Subject: FW: Oldlands Farm

AL/58/15/OUT

Oldlands Farm, Steyning Way, Bersted

Figure 8 - Flood Map

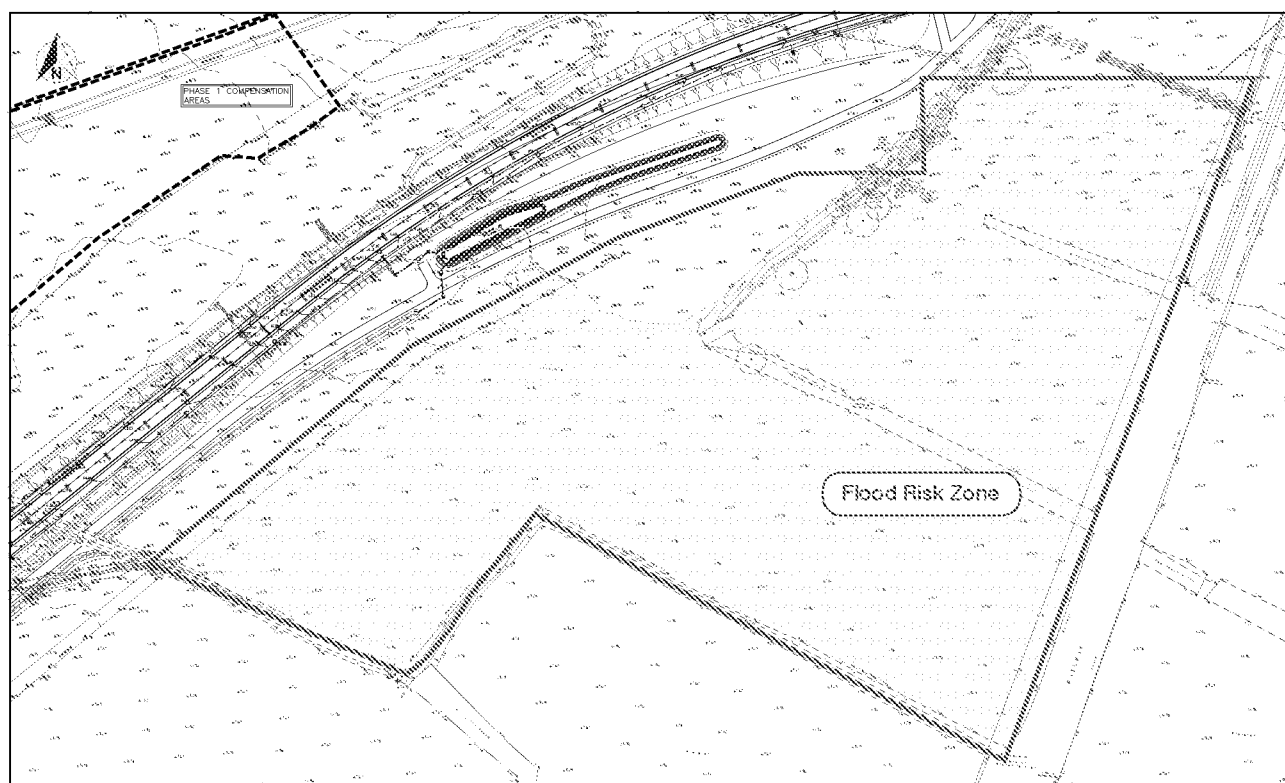
- The submitted Flood Risk Assessment acknowledges that the majority of the site lies in Flood Zone 3. As mitigation, flood compensation works are proposed and the development platform would be 'lifted out' of the vulnerable flood zone. In effect, you propose that the site would become Flood Zone 1. I don't necessarily disagree with these conclusions, but the development proposal as it stands lies within Flood Zone 3. The engineering solutions you have put forwards are mitigation measures. Therefore, the application should be accompanied by a Sequential Test.

Figure 10 - Access & Movement

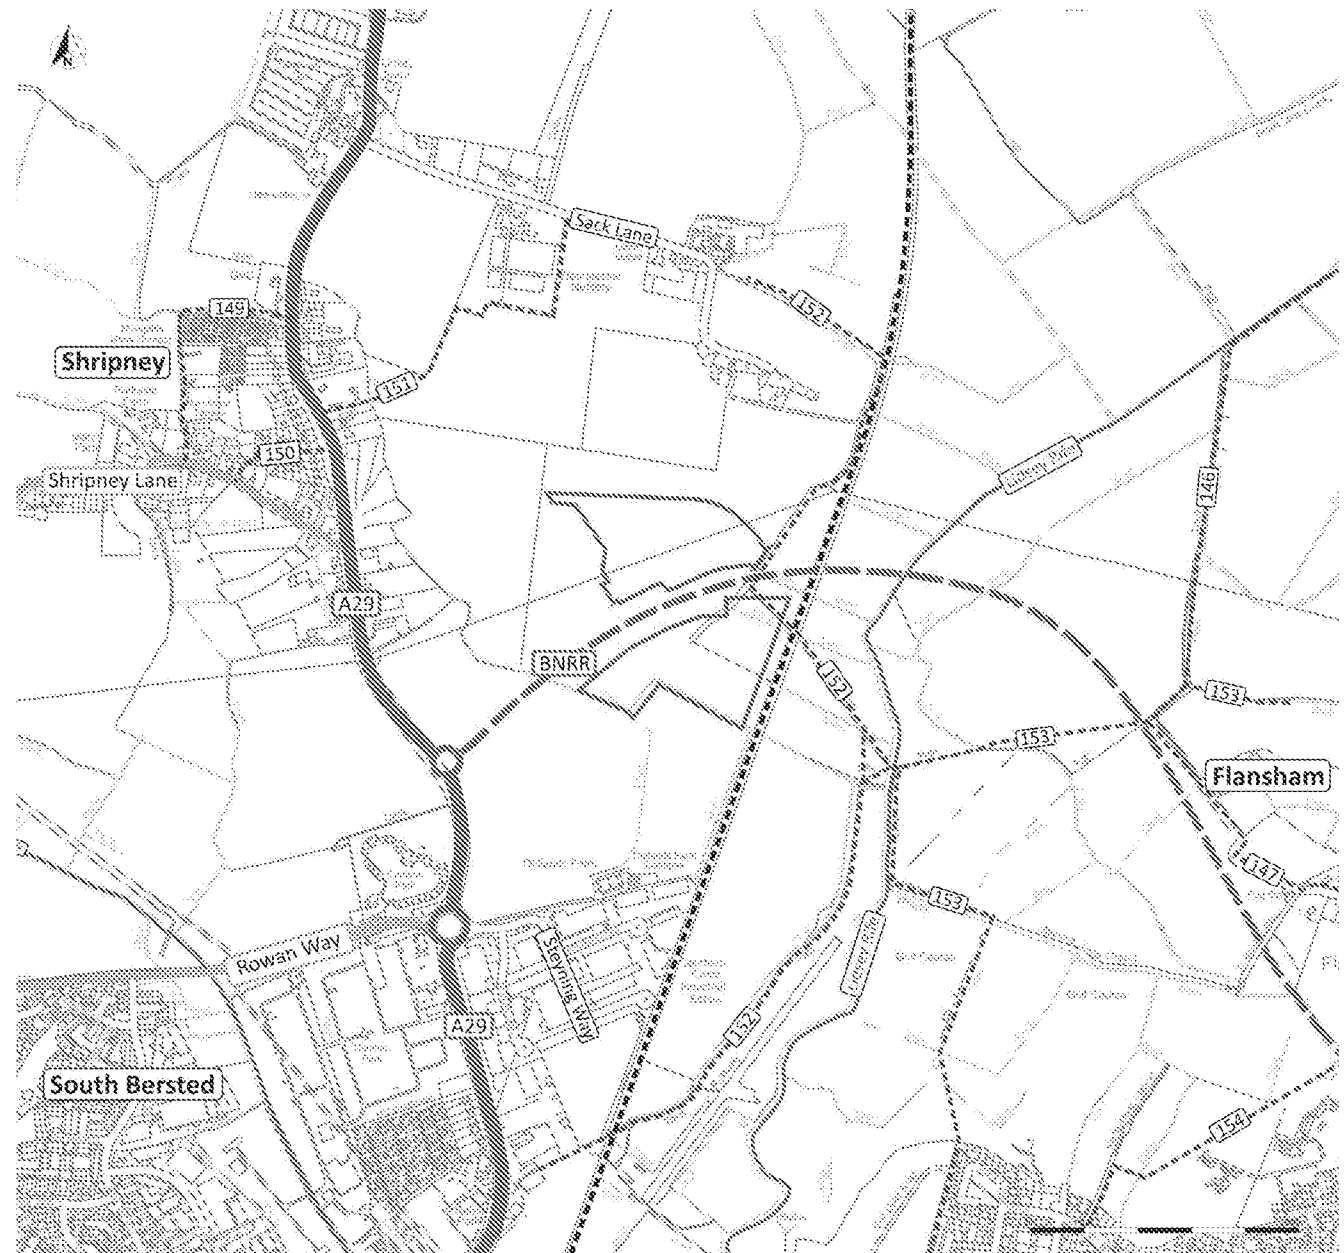
- Can you confirm the precise location of footpath 152? Whilst I appreciate it is currently closed for a temporary period, I understand it runs close around the perimeter of the site. I assume it outside the boundary of the site?
